PCD File No. PPR-21-050
Colorado Springs Utilities NE Gravel Staging Area

Lighting Plan

E1.01
 SITE LIGHTING PLAN

ATTACHMENT 5 – Lighting Plan

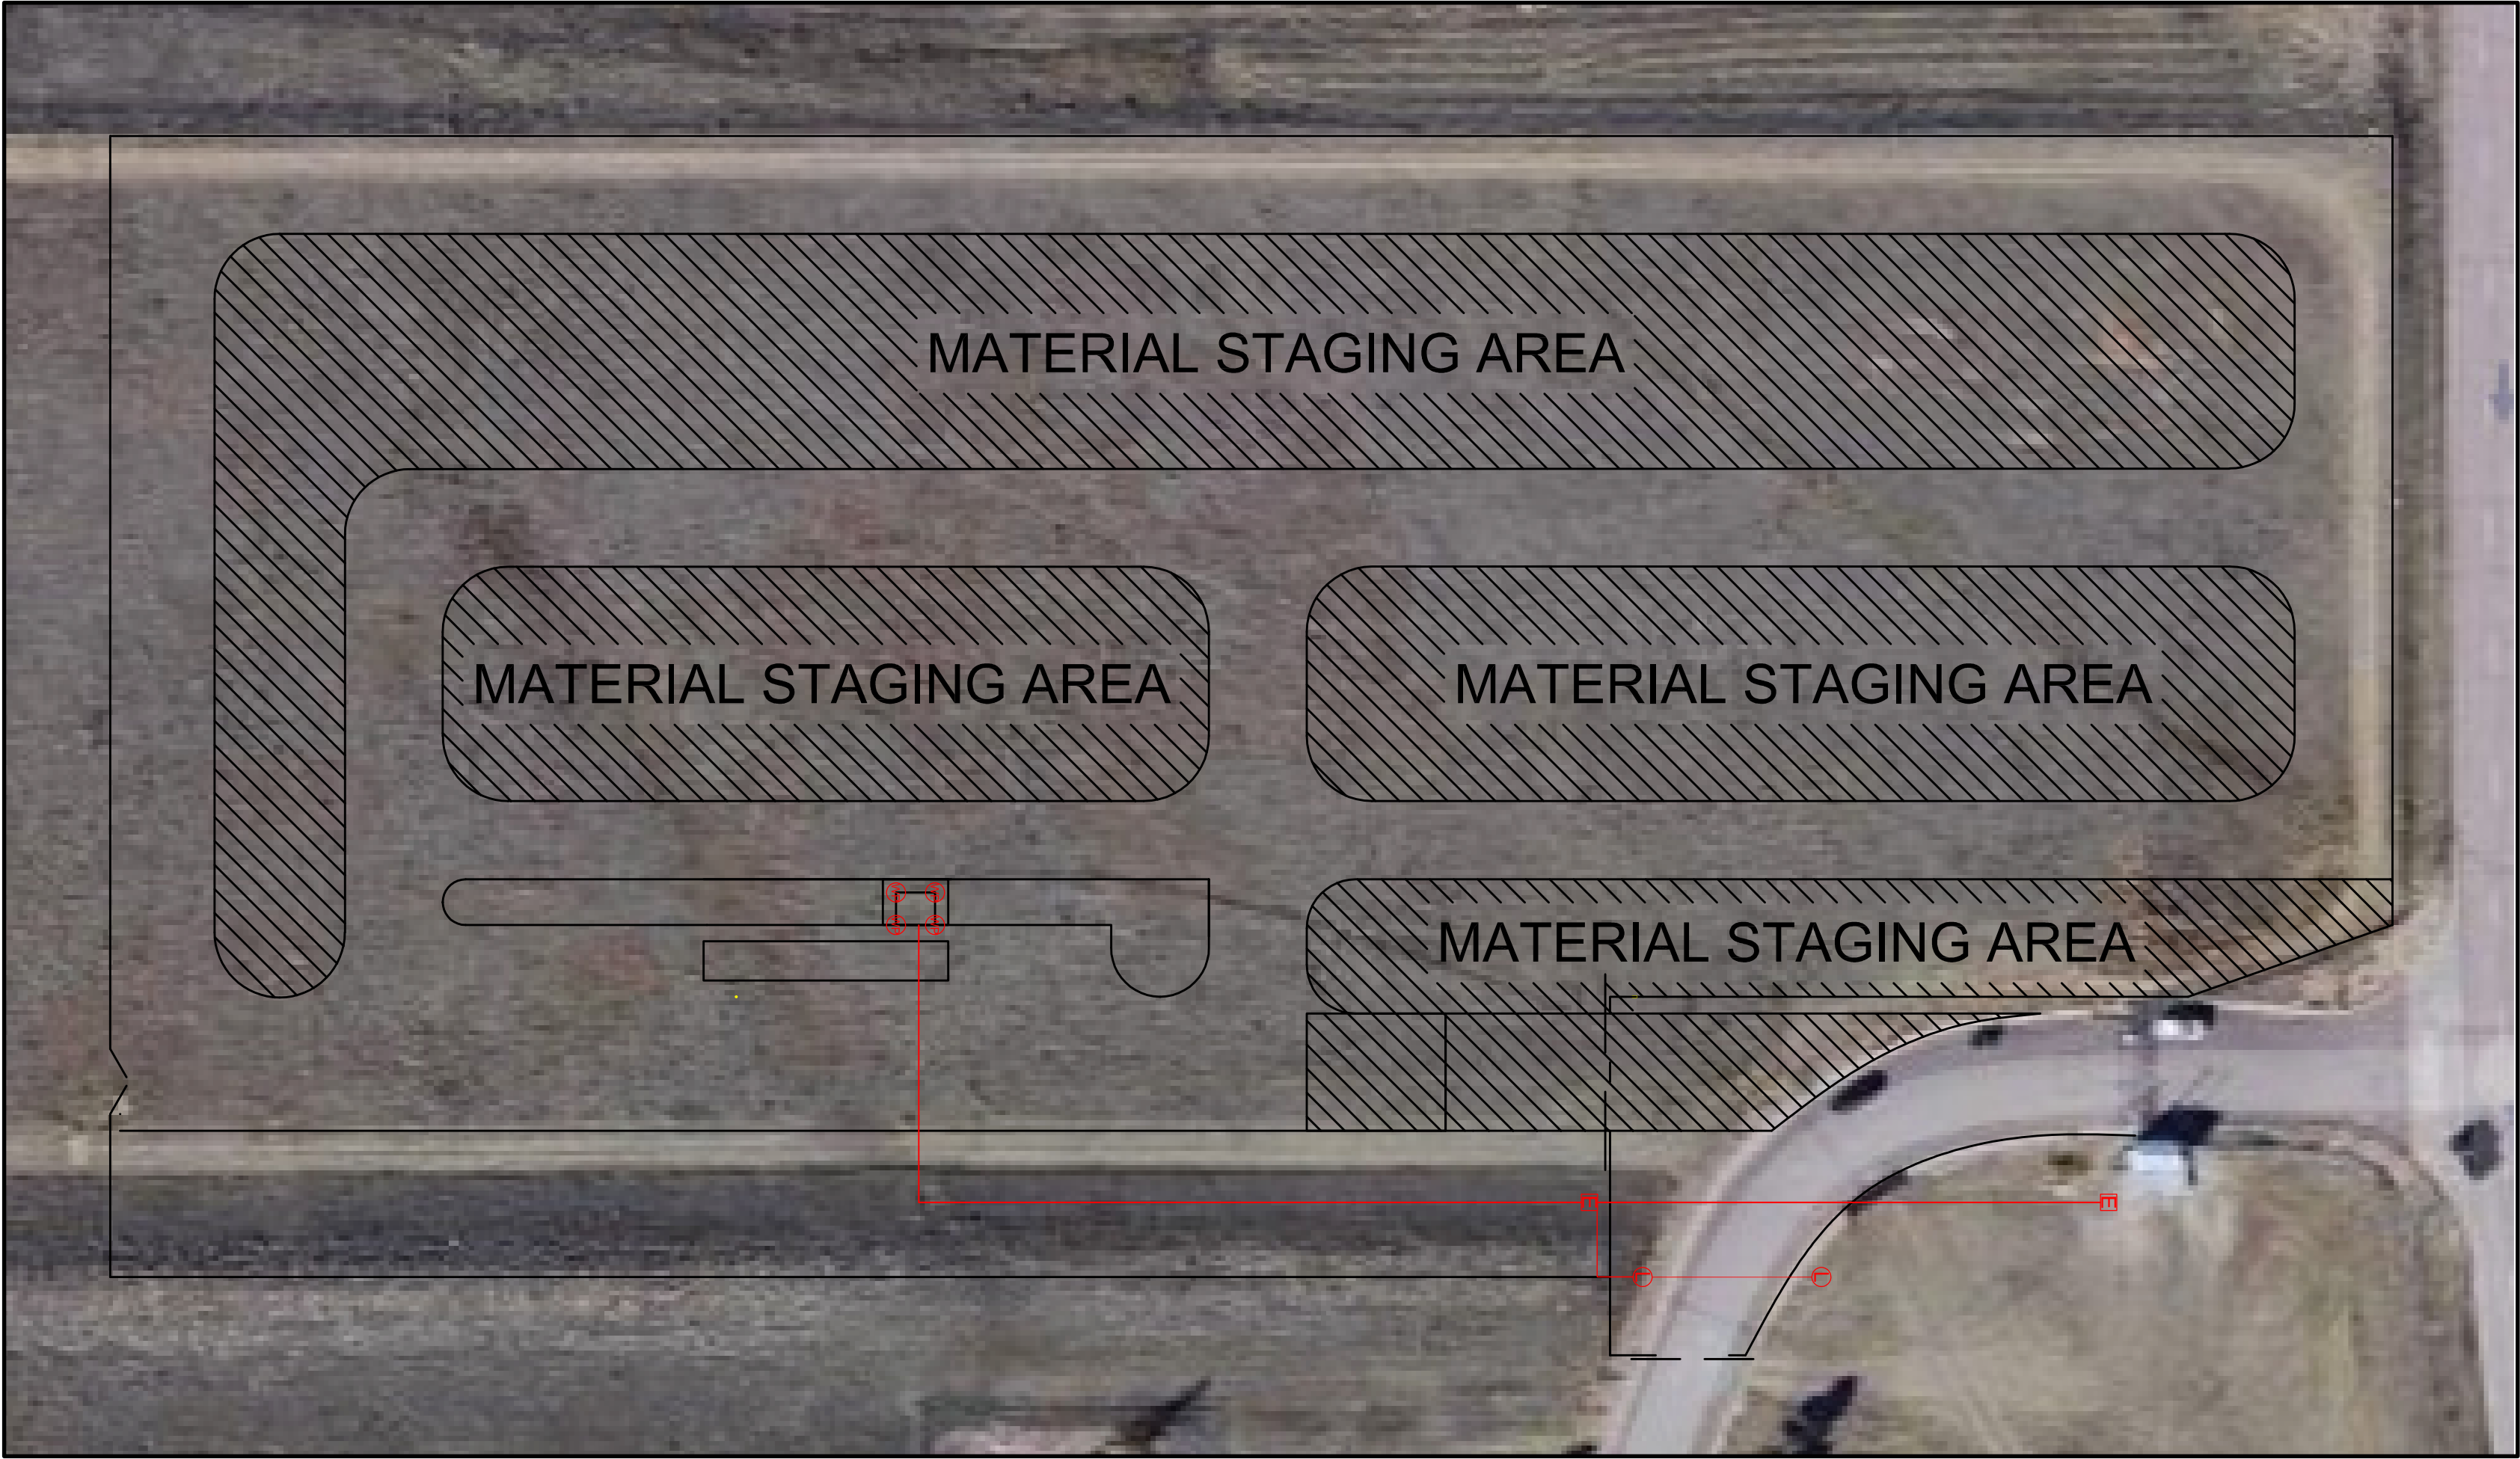
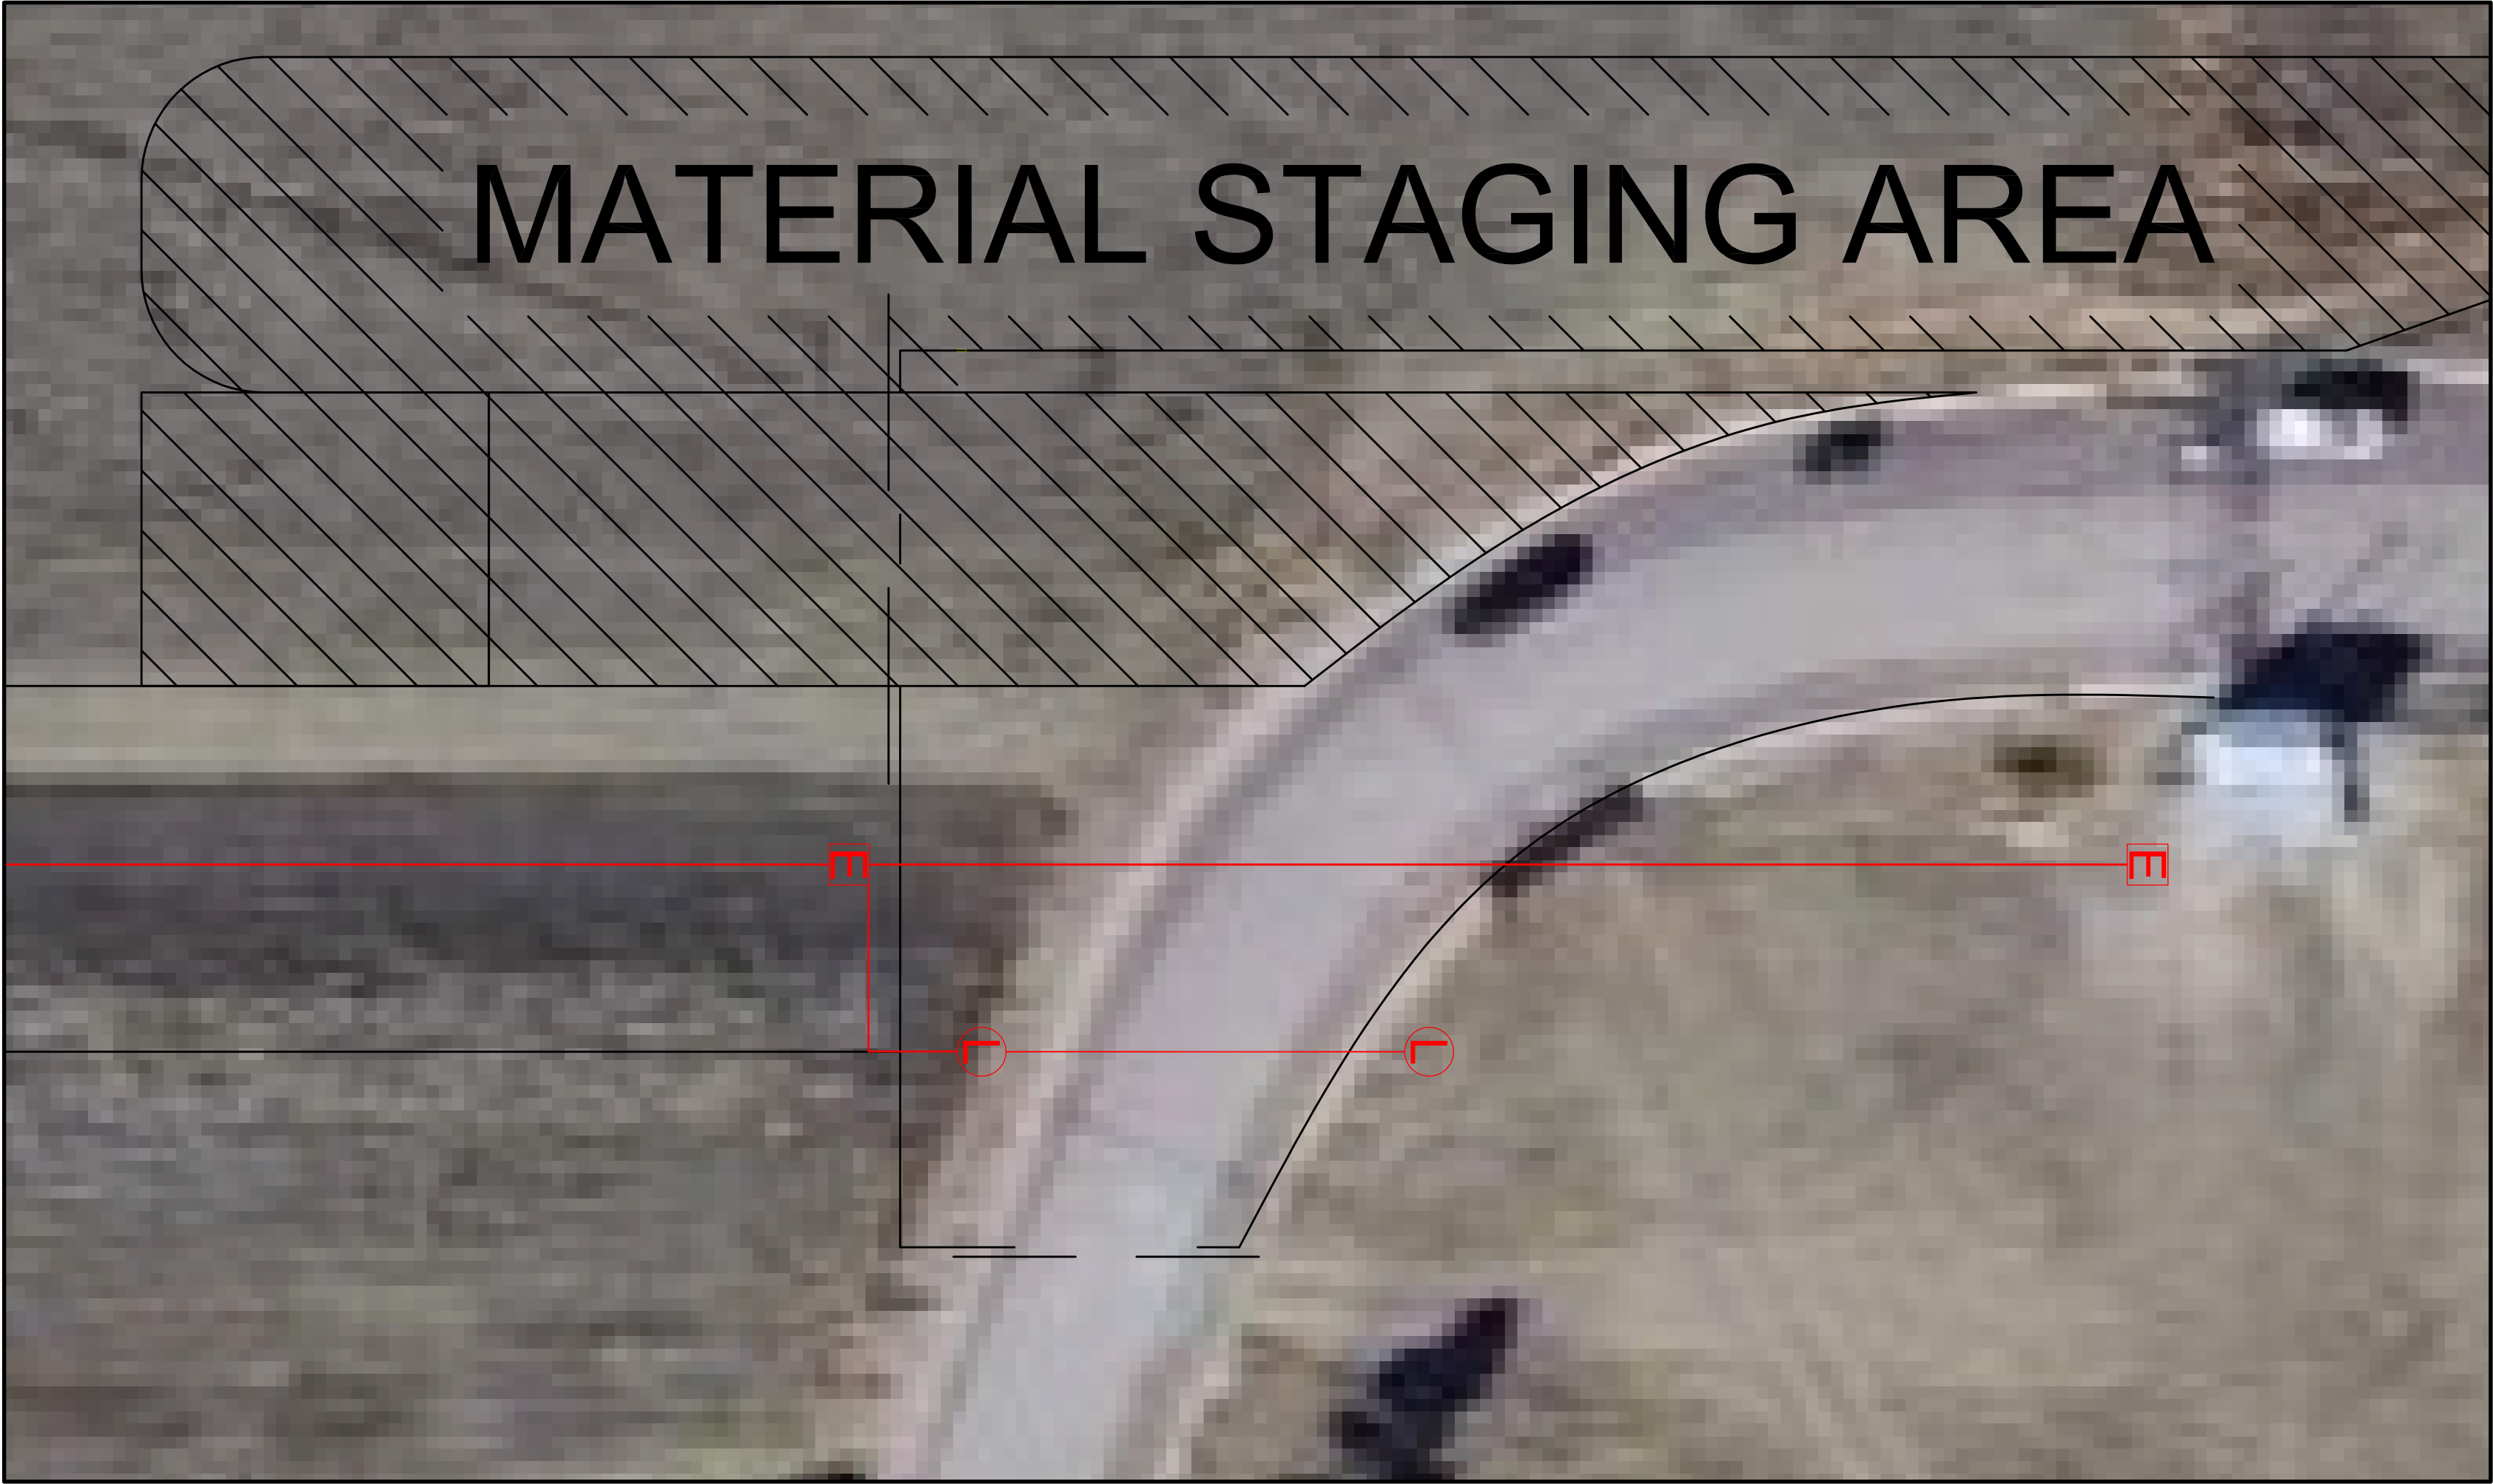
Previous comment unaddressed: the following have not been included.
 Photometric plan depicting the lighting levels (foot candles) throughout the property, at property lines, and along any adjacent rights-of-way.

- SYMBOLS**
- (E) ELECTRICAL PANEL
 - (H) HOFFMAN BOX
 - (G) GATE OPERATOR
 - (L) LIGHT POLE (15 FT. TALL, 62,235 LUMENS)
 - (R) CARD READER PEDESTAL
 - (WP) WALL PACKS (7 FT. TALL, 7,200 LUMENS)
 - (A) DIRECTION OF TRAFFIC
- Detail page says 25 ft

LDC Sec. 6.2.3.B.2: Height. No freestanding light fixtures shall be mounted higher than 15 feet, except parking lot light fixtures which shall be mounted no higher than 20 feet unless an alternative lighting proposal is approved in accordance with this Code. Please revise.

This lamp has no cutoff. Please review the following LDC Sec. 6.2.3.B.1.a:
